18/12/2019

**Alterations and Additions to Meriden School (SSD-9692)  
Request for Additional Information**

PROPOSED ILLUSTRATIVE PLAN

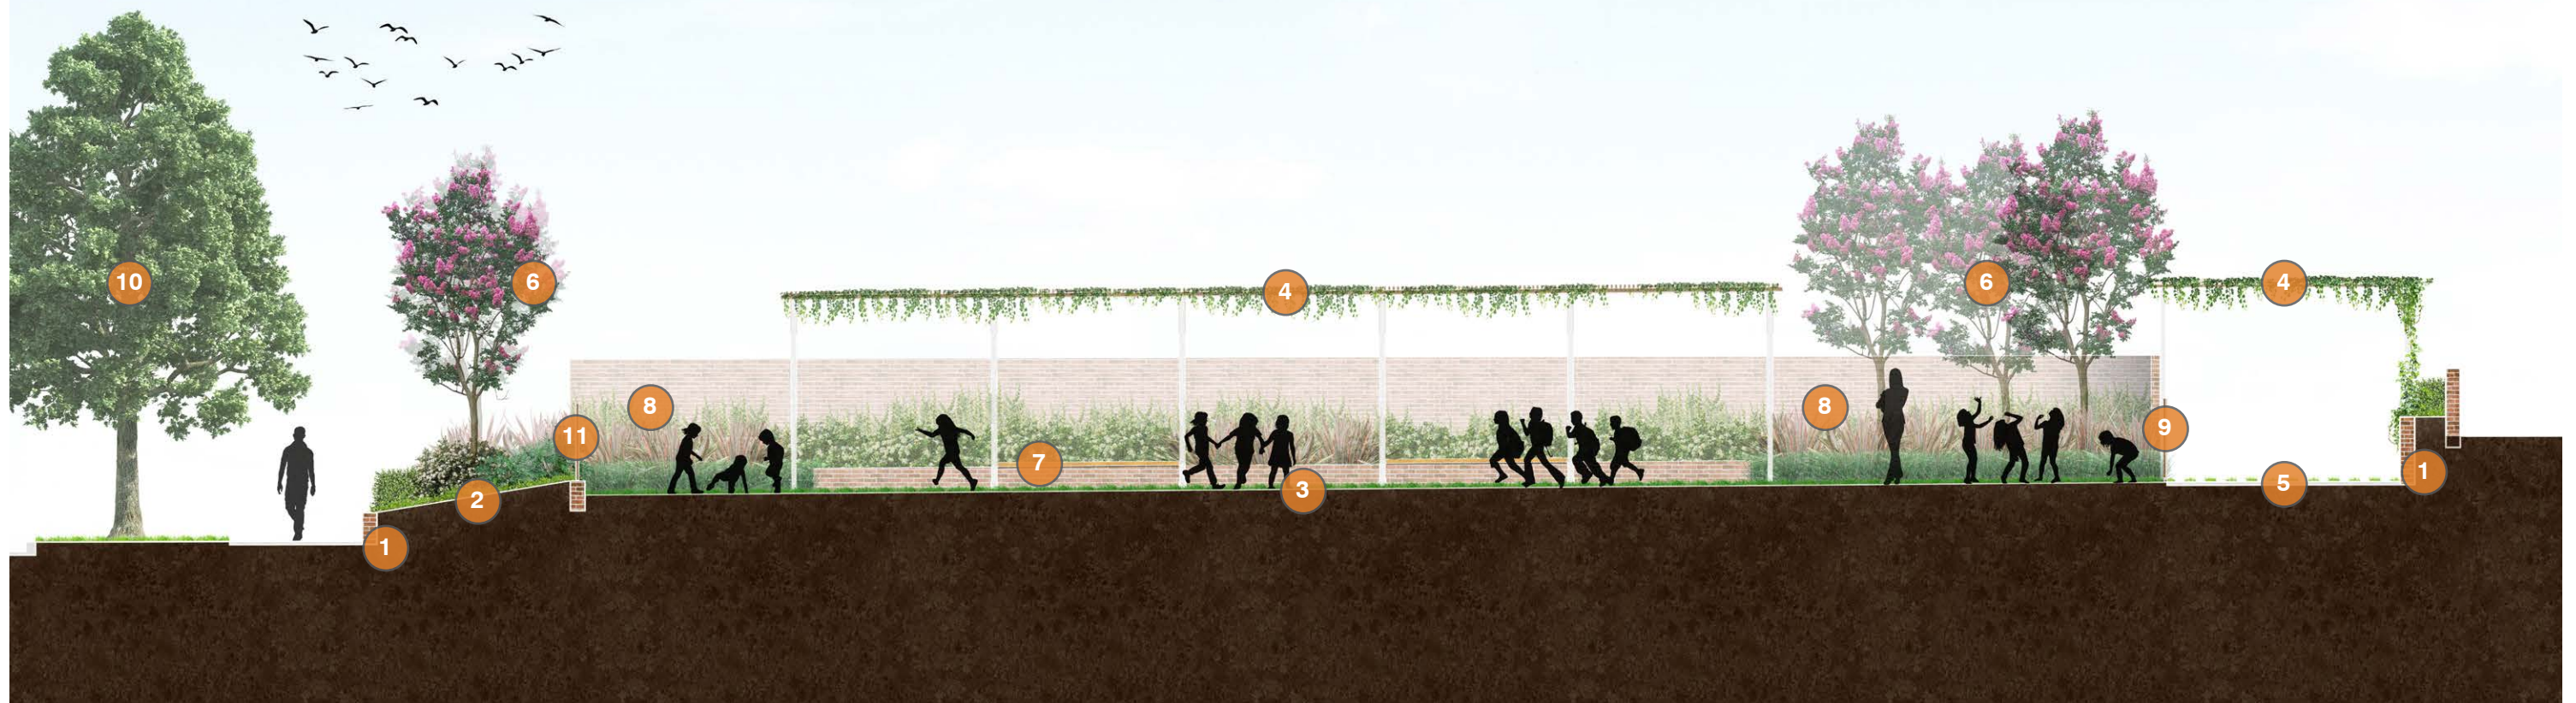
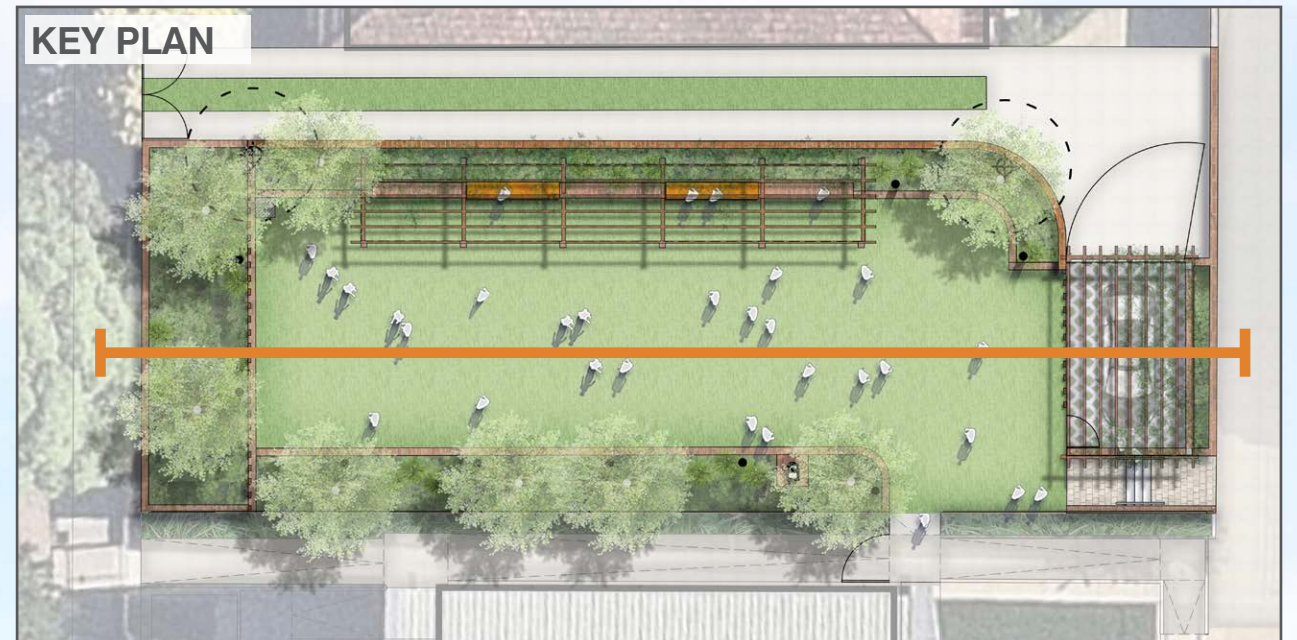
The RtS proposes that the existing 1.8 metre high timber fence between the Junior Campus and 2 Vernon Street should be made good so that there are no gaps in the timber construction. This is proposed in addition to the construction of an acoustic wall along the northern boundary of the proposed new adjoining play area and is referenced as part of the acoustic assessment included in the RtS.

The Department understands that there is no existing timber fence as referenced in the RtS and that the boundary between the above two properties is located along the centreline of the shared driveway that runs between the two existing dwellings. If this is true, making good works to the fence as set out in the RtS would not be possible.

- confirmation of the existence of the 'existing' fence referenced in the RtS and the location of the site boundary.
- if making good works to the 'existing' timber fence is no longer proposed, confirmation that the predicted noise levels from the use of the proposed adjoining playground do not rely on the upgraded 1.8 metre high fence in order to comply with the 43 dBA project noise trigger level.
- where it is determined that proposal without the fence does not comply, additional mitigation measures must be provided.
